## ADDENDUM 01

Date: February 21, 2017

Regarding: **191 Marginal Way Retail Center** – Portland, Maine

Subject: **Addendum 01**

C4 WINDOW TYPE C JAMB DETAIL
REFERENCED FROM: A8.01
SCALE: 3"=1'-0"

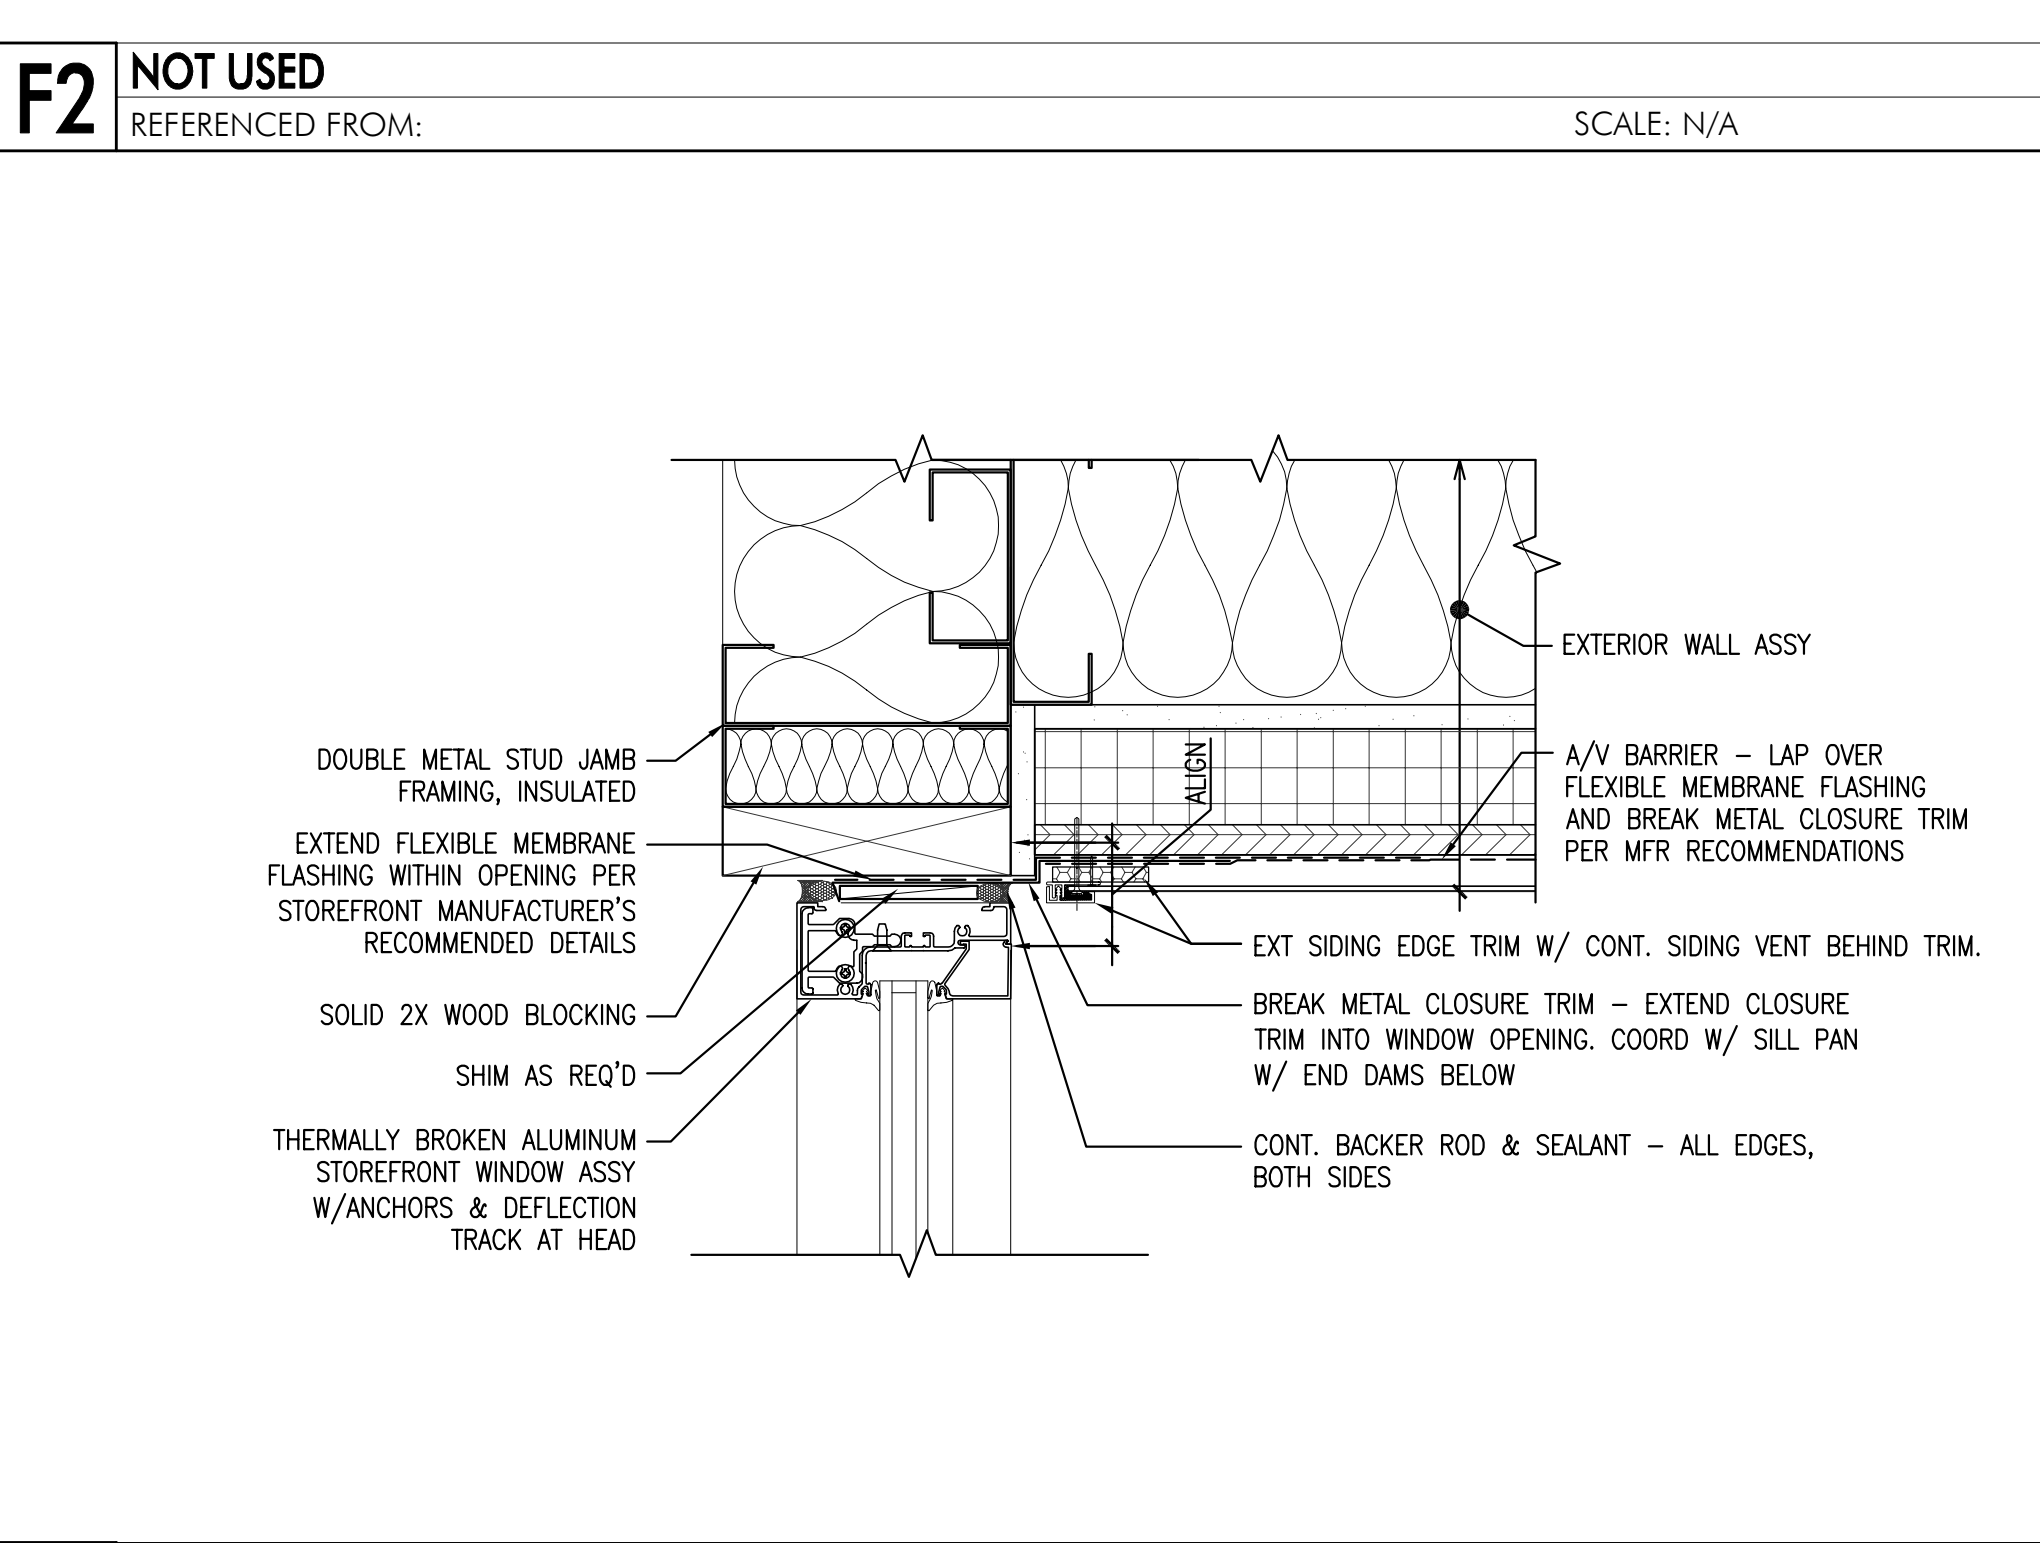
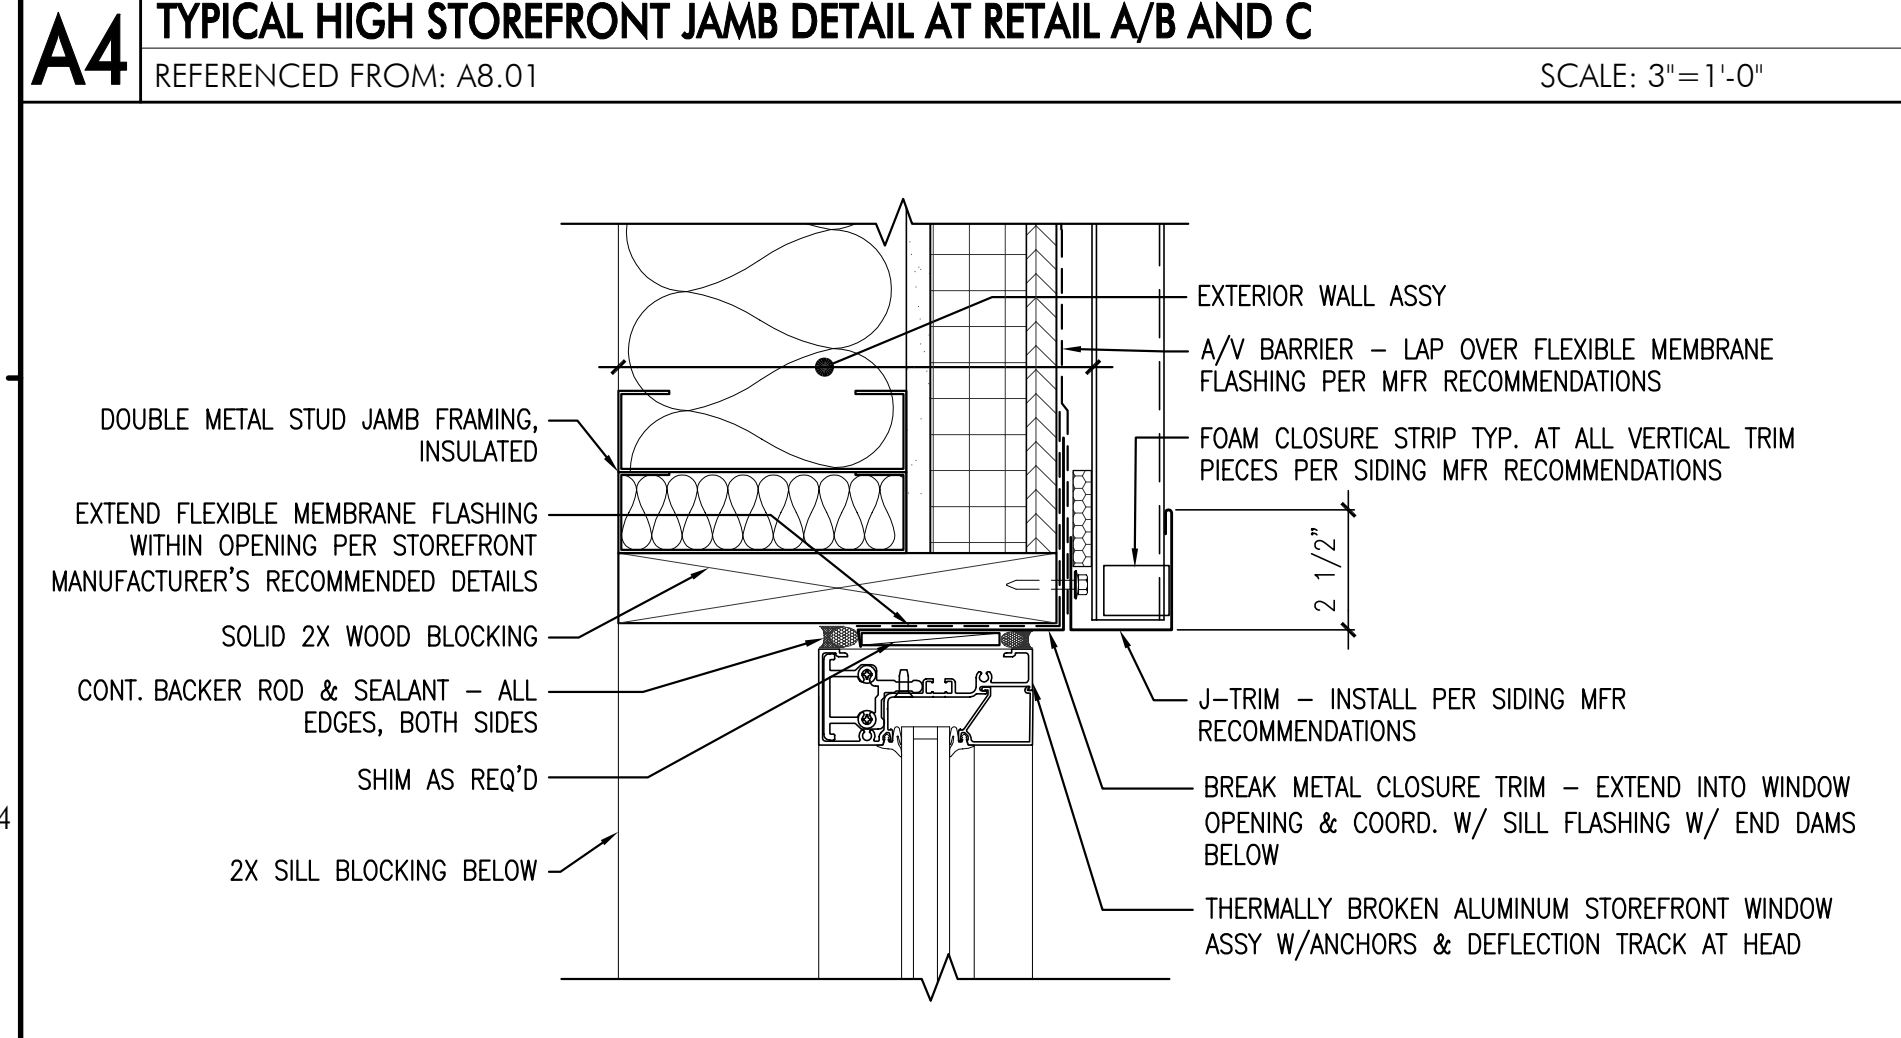
10. Sheet A6.11 – Drawings A5 and F5, delete callout for detail A4/A7.11. Refer to revised sheets A8.01 and A8.02 for door threshold detail callouts.
11. Replace sheets A8.01 and A8.02 with attached sheets, revised February 21, 2017. (Revised drawings now include detail callouts for window, storefront, and door details, on sheets A8.02 and A8.10)
12. Add A8.10 WINDOW AND STOREFRONT DETAILS to set.
